Final Report - Corrections Required **Application No. ANEX-24-0002**

Description : Matrix Design Group on behalf of Colorado Springs Equities LLC is submitting a serial annexation petition for seven parcels and Land Use Plan/Rezoning exhibit for a portion of the subdivision known as Rock Creek Mesa.

Document Filename : Rock Creek Mesa Addition No 1 _ Annexation Plat_V3_5-13-24

## ROCK CREEK MESA ADDITION NO. 1

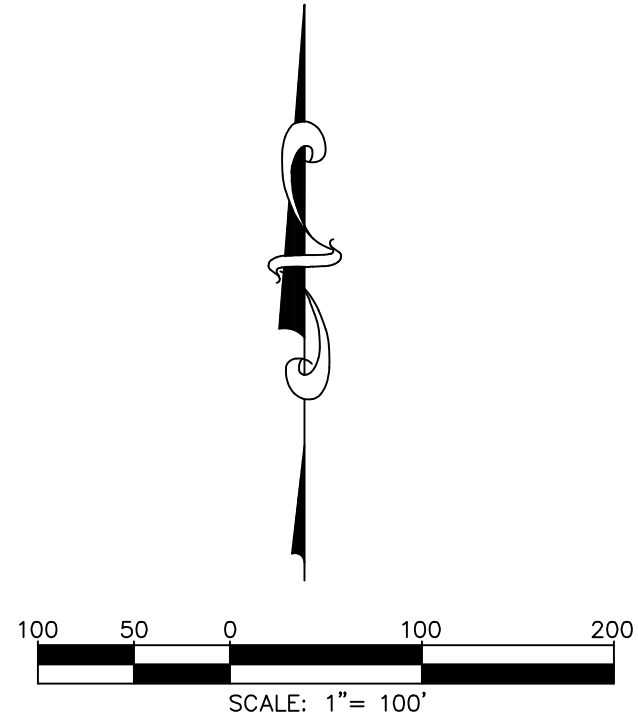
Comment ID	Page Reference	Reviewer : Department	Review Comments
31	1	Cory Sharp : Planning	please determine the name and title of the person signing and complete under owner and notary (so we are not waiting till the end and it be overlooked)
32	1	Gabe Sevigny : Planning	Following Comment if from the School District: We only have one concern which is whether the developer is able to donate any land for an elementary school. 400 homes could generate 600 students - with approx. 350 elementary students and 250 secondary students. The existing schools on Fort Carson do not have the capacity to absorb that many elementary students. We typically need 12 acres or so for an elementary school. We may also need to add a preschool too. (Contact: Vergunst, Joanne jvergunst@FFC8.org) Note from Planner, this will need to be resolved prior to public hearing
30	2	Cory Sharp : Planning	previously requested, please add the label for this linework, centerline former Canyon City Highway R.O.W. Book 473 Page 64 (per other drawing)

previously requested, please
add the label for this linework,
centerline former Canyon City
Highway R.O.W. Book 473
Page 64 (per other drawing)
